From: [Jim Leff](#)
To: [Kelly Bacon \(CD\)](#)
Cc: tamileff@msn.com
Subject: Comments on -- Miscellaneous SEPA Applications - SE-22-00002 Cape
Date: Sunday, February 13, 2022 9:50:01 AM

These comments pertain to application for permit for drive way improvements as documented in "Miscellaneous SEPA Applications - SE-22-00002 Cape". Found online at:

Parcel #19162 Driveway Improvement Extents

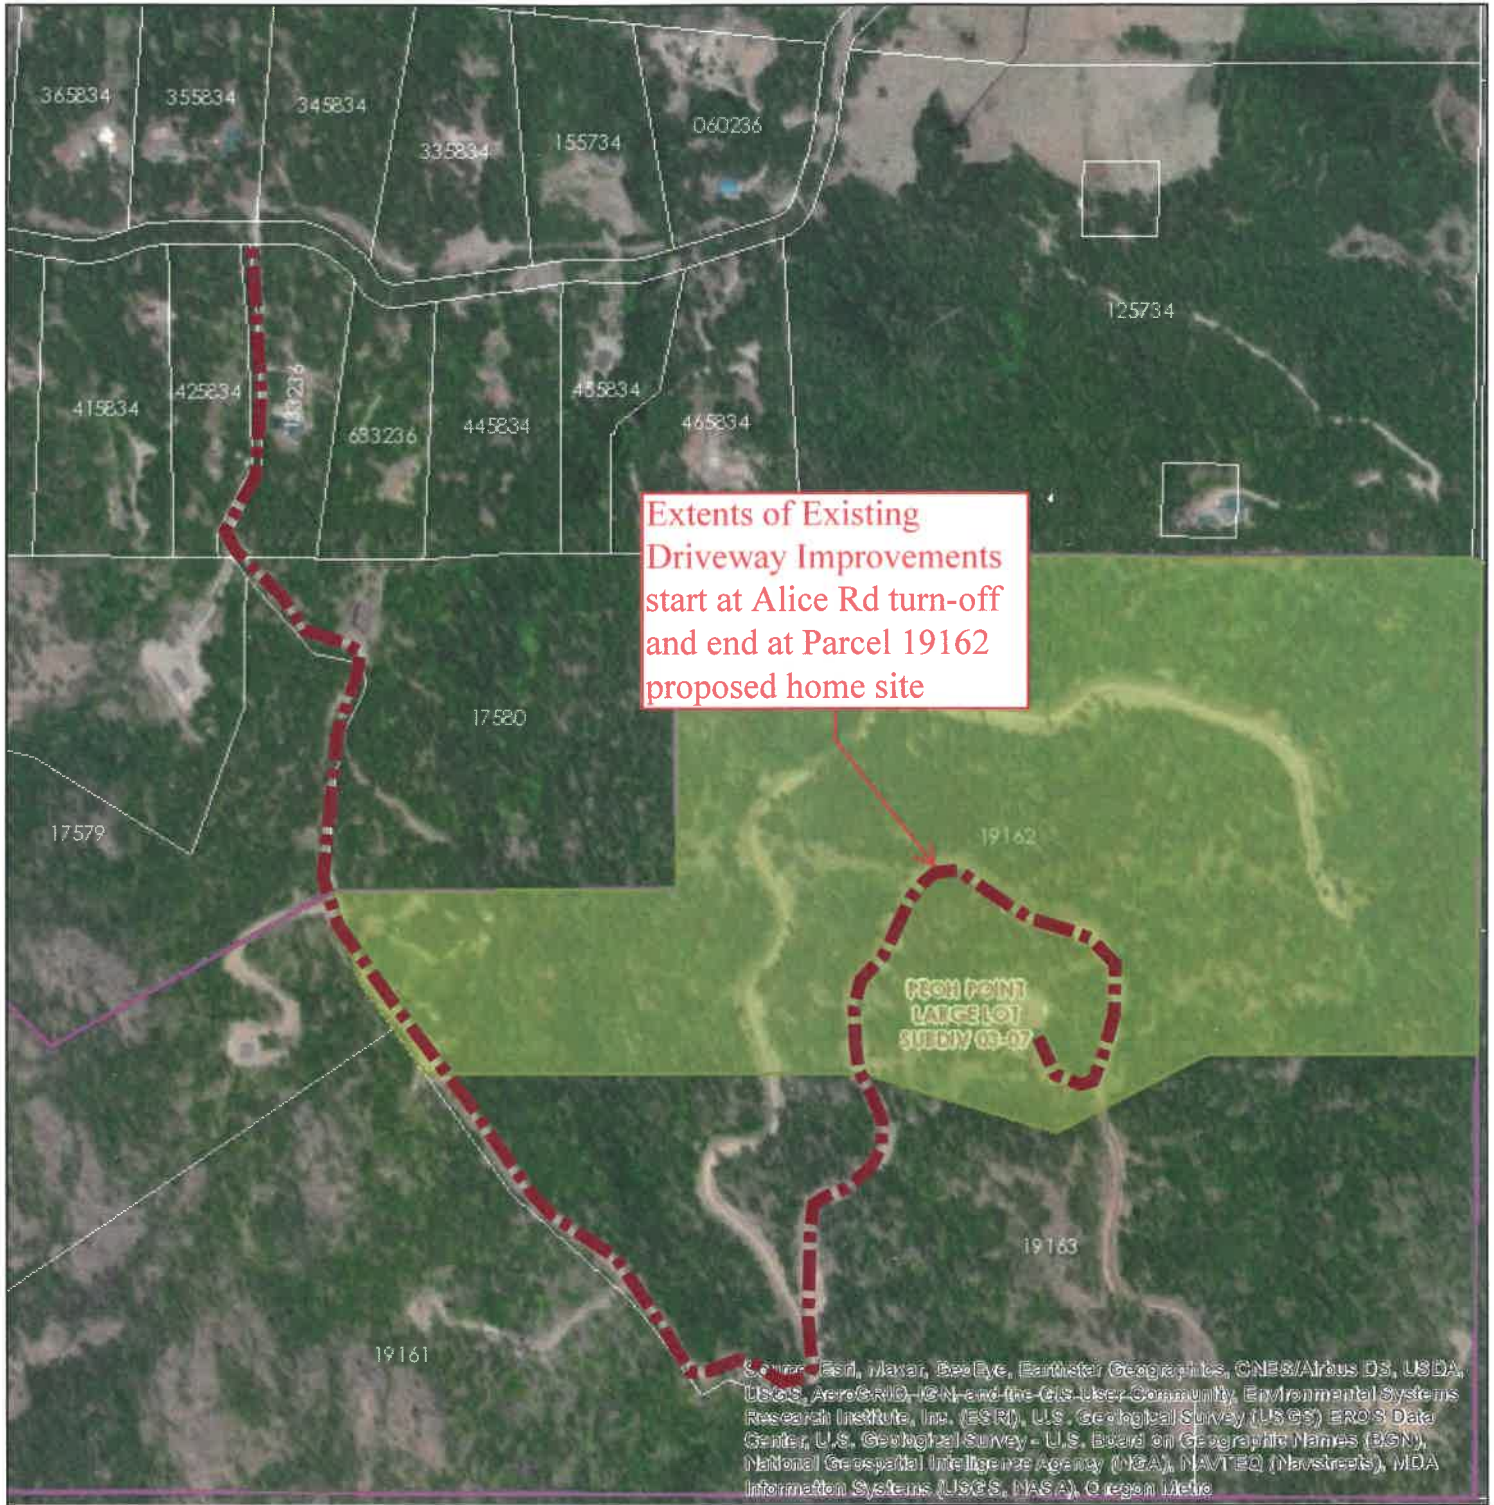
We are concerned about any widening of the current gravel road (originally developed by Sapphire Skies). Our barn/cabin is relatively close to the gravel road and any expansion of the road in our direction would reduce our open space. Further, our electric transformer is at the bend in the road at the bottom of a steep hill. By increasing the speed of traffic on the driveway, particularly at this bend and in the winter, there is a higher chance that both the barn and the transformer could be damaged either during or after construction due to accidents.

Potential mitigations for this might include short and long-term fence/barrier construction to protect the property during and after construction and a review of the exact location of the proposed road edge with a focus on limiting negative impact to our property – particularly in the areas near our transformer and our barn.

During a heavy rain, even the current gravel road becomes a stream that runs down the hill toward our barn. With less permeable road surface, we can expect that this runoff and the associated chance of erosion will increase, and that it could also impact water quality in our area. We would like to be assured that all relevant water-quality protective measures are adhered to, and to see and understand the mitigation plan related to potential runoff and erosion issues, including any inspection and oversight provided by the county for this project.
